REFUSAL OF PLANNING PERMISSION

APPLICATION NO. 2013/0383

Proposal Erection of front porch, front dormer extension and detached double garage.
At 16 George Street, Middlecliffe, Barnsley, S72 0HL

FRONT ELEVATION - PROPOSED

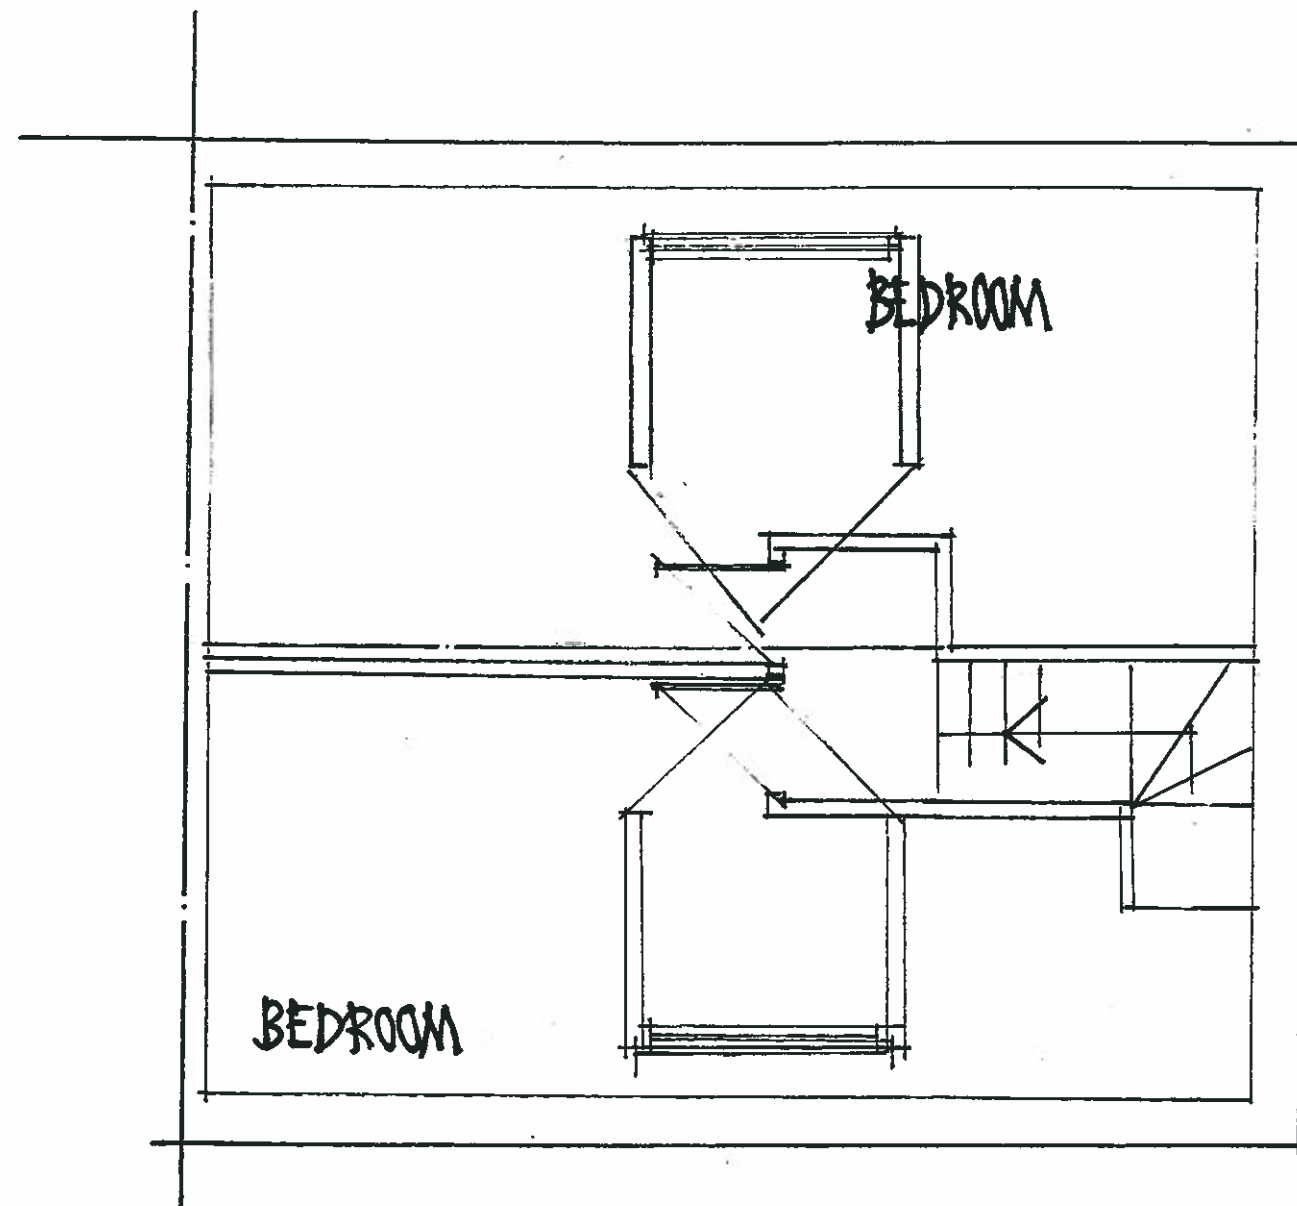
- 1 In the opinion of the Local Planning Authority the proposed dormer extension would be contrary to Policy CSP29 of the Core Strategy and the Council's Supplementary Planning Guidance on House Extensions in that its design and siting would detract from the appearance of the property and would, as a consequence, appear as an unduly intrusive feature in the street scene where there are currently no other front dormers.
